ENG-PUDSP21006-R1-PDR.pdf Markup Summary

PRELIMINARY DRAINAGE PLAN
PUDSP 21-00X

THE RIDGE AT LORSON RANCH
MARCH, 2021

**SEE POND EXHIBIT FOR POND LOCATIONS

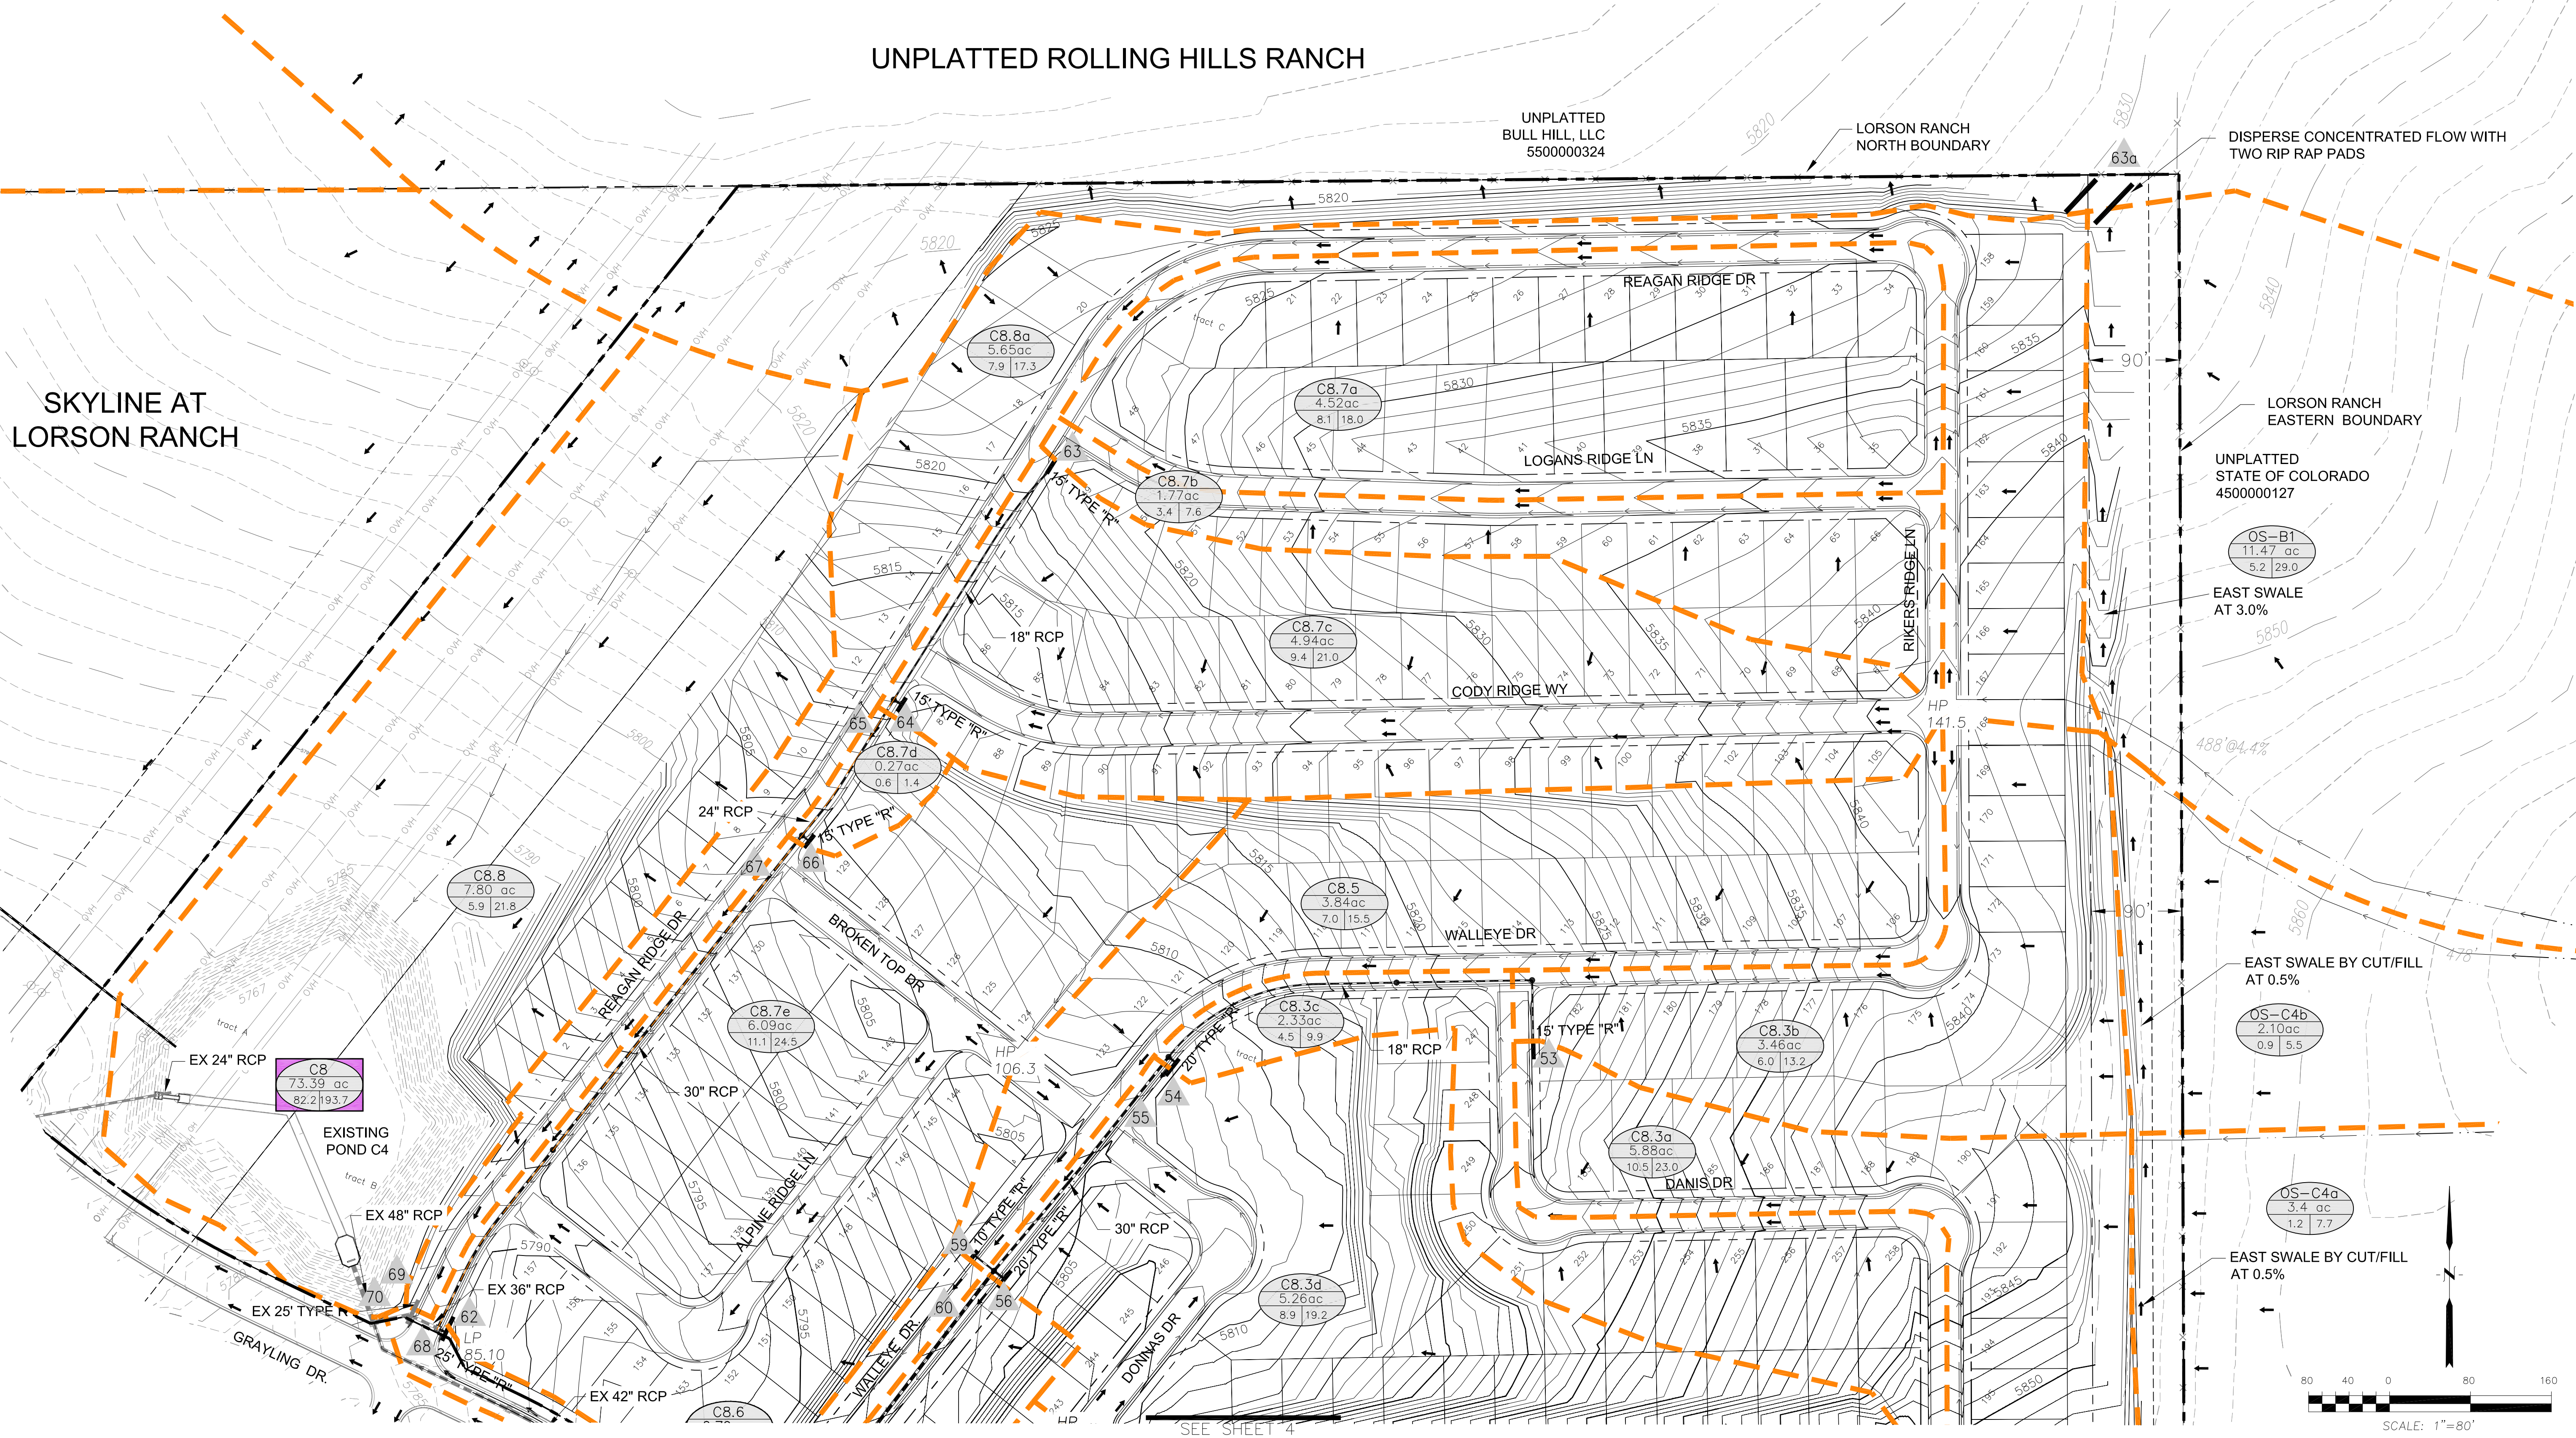
Show and label linetype for areas tributary to each pond as shown on Page 143, typical for all 4 plan sheets.

Label inlet

show existing curb and gutter

If inlet could overtop with flows >100-yr storm, consider providing a berm or wide swale to ensure that flows don't enter Lot 357.

What is the flow from this area and is a larger swale needed between lots?

Where would approximate low point be for Meridian Road and what would future flow be?

is a conveyance needed to keep flows out of Lot 158?

~ 8 Ac?

Should this have the purple border for overall basin?
